Written Representation
Relating to A14 Cambridge to Huntingdon Improvement
Scheme

On behalf of Whitbread Group Plc

Objector Reference A14-AFP374

15th June 20125
SJT/17233-02_WR_Whitbread

Drawing title: **TRAFFIC REGULATION MEASURES REGULATION 5(2)(o) CLEARWAYS & WEIGHT LIMITS SHEET 4 OF 36**

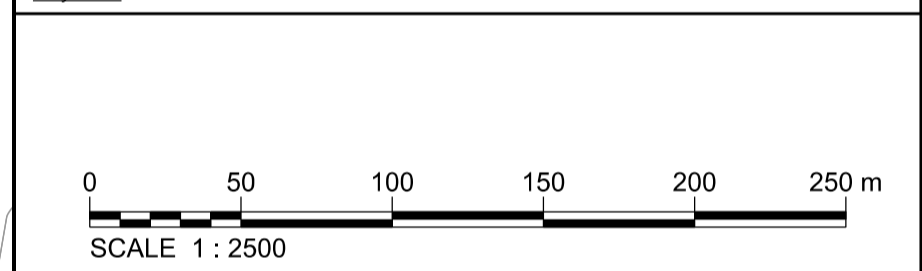
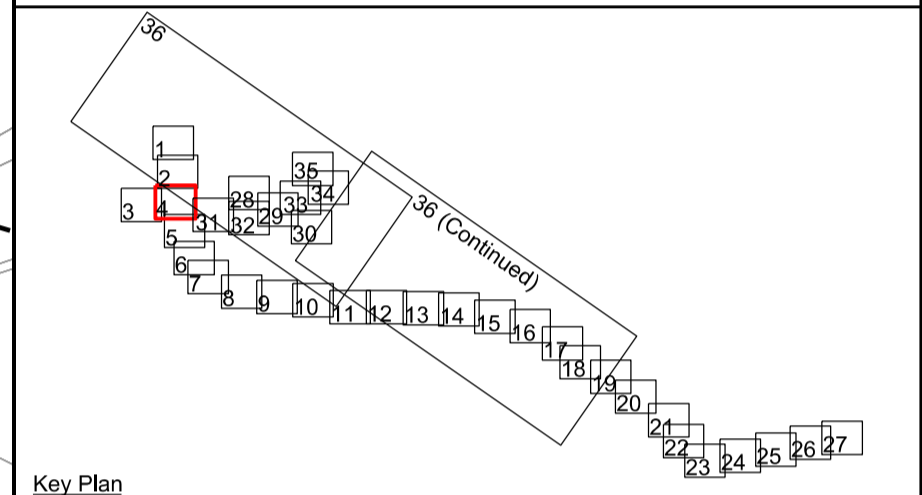
- 3.0 Whitbread Group PLC object to the scheme in relation to the changes at Brampton Hut Services. HE have indicated that there is no requirement to acquire any land from the company. Until this such time as this has been confirmed, Whitbread Group PLC object to the CPO and DCO on the basis that it has a potentially significant adverse impact on the company's operations.

- 4.0 In addition, the revised highway layout will remove A14 traffic from the Brampton Hut junction, through the creation of a bypass link. The facility is currently signed from all approaches (A14 and A1). It is therefore essential that appropriate signing is provided for A14 traffic to the facility. The objector requests details of the proposed signing for review and further comment.
